CITY OF ALBUQUERQUE

Site: "Paseo Nuevo Parking Lot" – C18E074A

Re: Drainage Ordinance (14-5-2-1) Violations for Erosion and Sediment Control

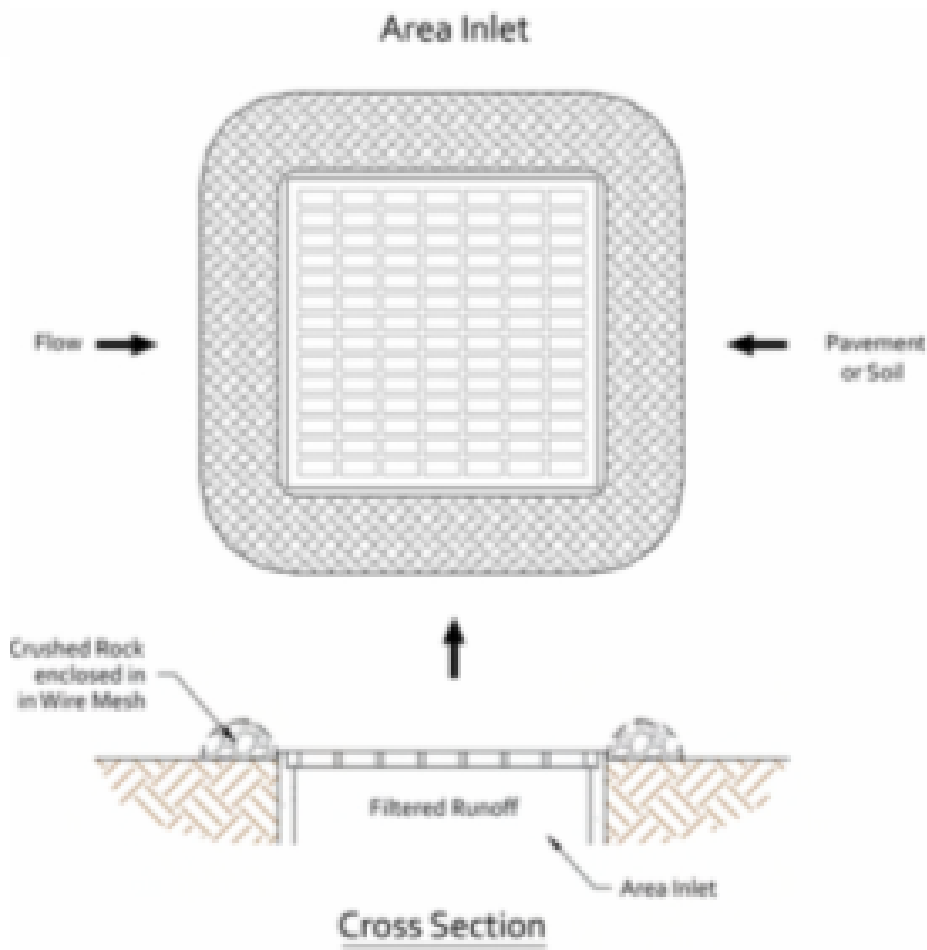
1. Silt fence has holes in it and too much dirt piled against it. It is not adequately embedded. See the 2018 Construction Site manual at <http://documents.cabq.gov/planning/DevelopmentReviewServices/Construction%20Site%20Inspection%20Standards%2012-3-18.pdf> for proper silt fence installation and maintenance standards.

2. Construction and domestic waste not in approved containers.

3. Sediment in driveway and in Holly street and sidewalk.

1. Maintain stormwater controls including silt fence.
2. Dispose of construction and domestic waste in acceptable containers daily and use lids or tarps to cover waste containers when not in use per CGP 2.2.3.e
3. Where sediment has been tracked-out from your site onto paved roads and sidewalks remove the deposited sediment by the end of the same business day in which the track-out occurs per CGP 2.2.4.d.
